**Date:** September 21, 2012

**Re:** Ledgewood Drive 14 Lot Subdivision, 1062 Ocean Avenue  
TPO Properties, LLC, Tim Donovan  
Preliminary Review

**Project #:** 2012-584                      **CBL:** 414-A-4 (Part Within Town Of Falmouth)

**Meeting Date:** September 24, 2012

PLAN OF PROPERTY
 OCEAN AVE. & LEDGEWOOD DRIVE
 PORTLAND, MAINE
 MADE FOR
TIM O'DONOVAN
 AUGUST 27, 2011
 BY
 CULLENBERG LAND SURVEYING
 892 OLD DANVILLE ROAD
 AUBURN, MAINE 04210
 (207) 777-1150

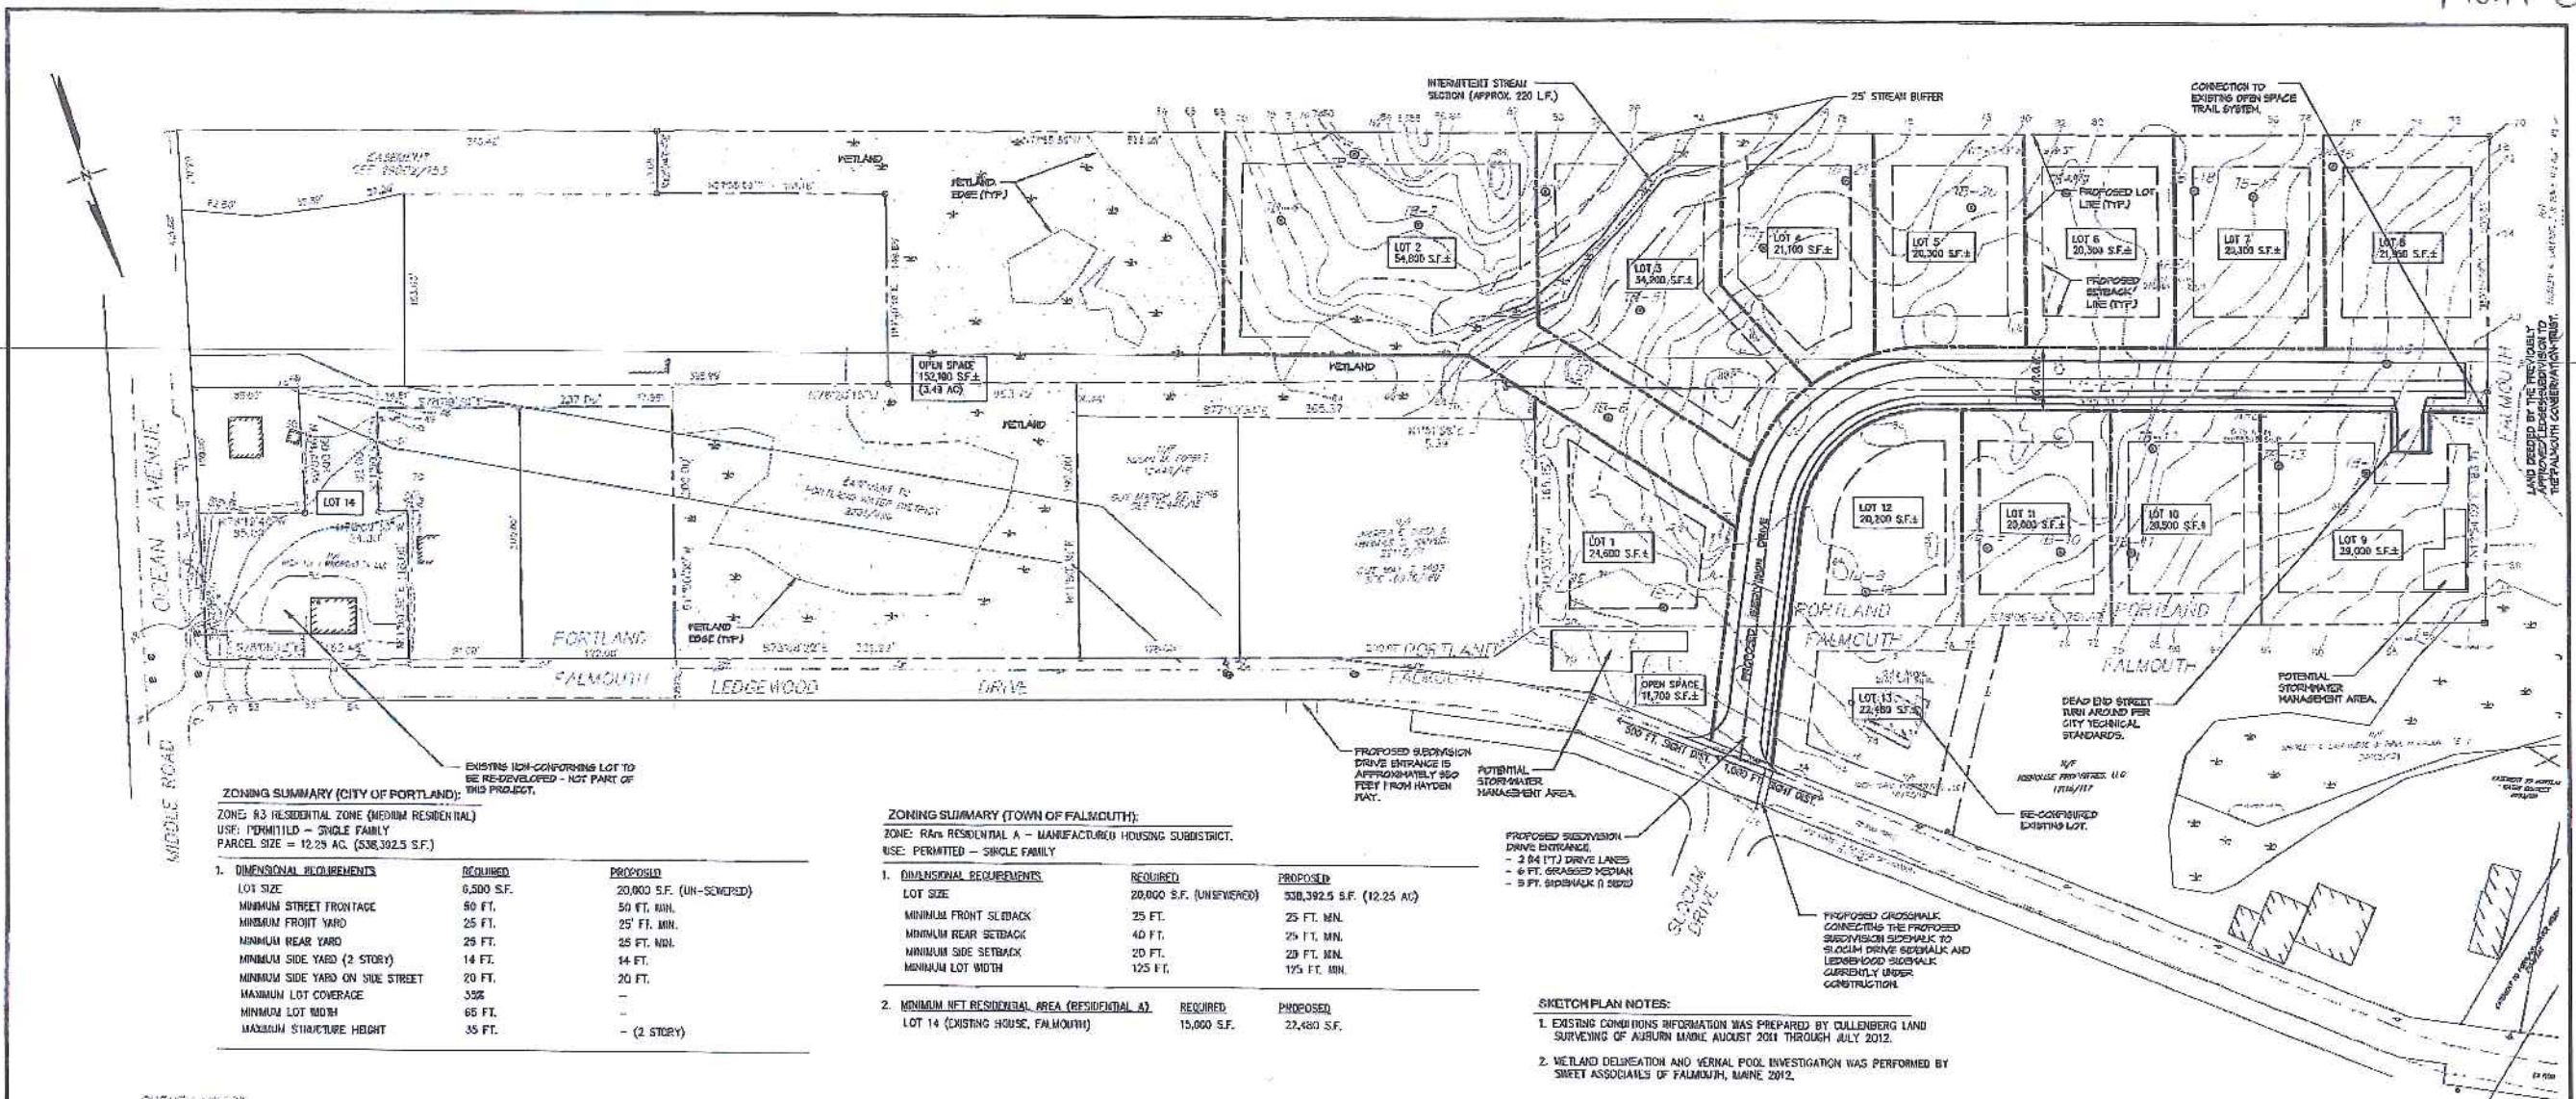
The proposed subdivision parcel includes a 50 foot wide easement (see [Plan 1 Survey](#)) that connects the proposed 13 lot subdivision to Ocean Avenue along the south side of the parcel, which potentially would allow a vehicular or pedestrian access from the subdivision to Ocean Avenue. The Subdivision Ordinance (14-498) includes the following:

Staff do not consider that a connection here (ie to Ocean Avenue) would be of particular benefit to the subdivision nor help achieve improved access, while links to the adjacent Portland open space (south and southwest of the site- see [Plan 2](#)) are recommended.
